Friday, 16 September 2022

## **Integrated Water Cycle Management Review of the Yiribana Logistics Estate in the Mamre Road Precinct**

The following is a summary of our review of the documentation provided to us by DPE against the Mamre Road DCP (Nov 2021). This proceeds from additional information supplied in response to our review from 9 June 2022, with supplementary assessments and modelling updates provided. This summary document will be laid out following the Controls laid out in the DCP.

Figure 7.1. MUSIC model layout

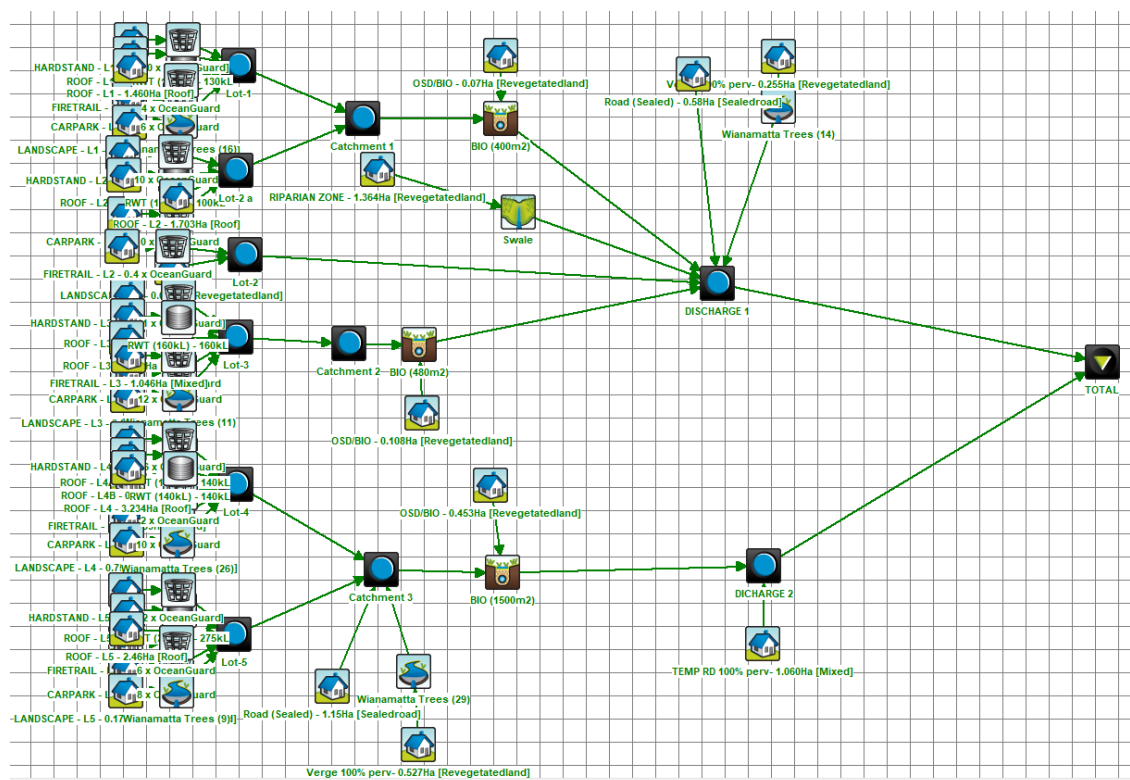
Several WSUD devices have a high flow by-pass of 100m<sup>3</sup>/sec. This is impossible and forces far more water through the WSUD devices that could ever physically drain through them. This provides inflated treatment train effectiveness. Street Trees have been updated, but all high flow by-passes must be individually calculated and presented in a revised summary report and MUSIC modelling.

The exfiltration rate in MUSIC is listed as 1mm/hr which is significantly larger than MUSIC modelling parameters used by other consultants in the Mamre Road Precinct. In addition to this the exfiltration rate for the street tree irrigation is 0.36mm/hr which is consistent with this other work. Site specific saturated hydraulic conductivity testing should be provided to justify these rates and a single rate adopted for the site.

Furthermore, an analysis of the earthworks model in the vicinity of the Riparian Storage shows excavation to depths of 2m-5m. It is therefore unlikely that a sufficient soil profile will be available for water to infiltrate in to. The proposed infiltration rates must also be justified with this in mind.

The exfiltration rate in the model has been revised to the lower value of 0.36mm/hr. A single rate for saturated hydraulic conductivity has been adopted in the model however saturated hydraulic conductivity testing has not been provided, nor has an assessment or commentary on the location of bed rock in relation to infiltration areas.
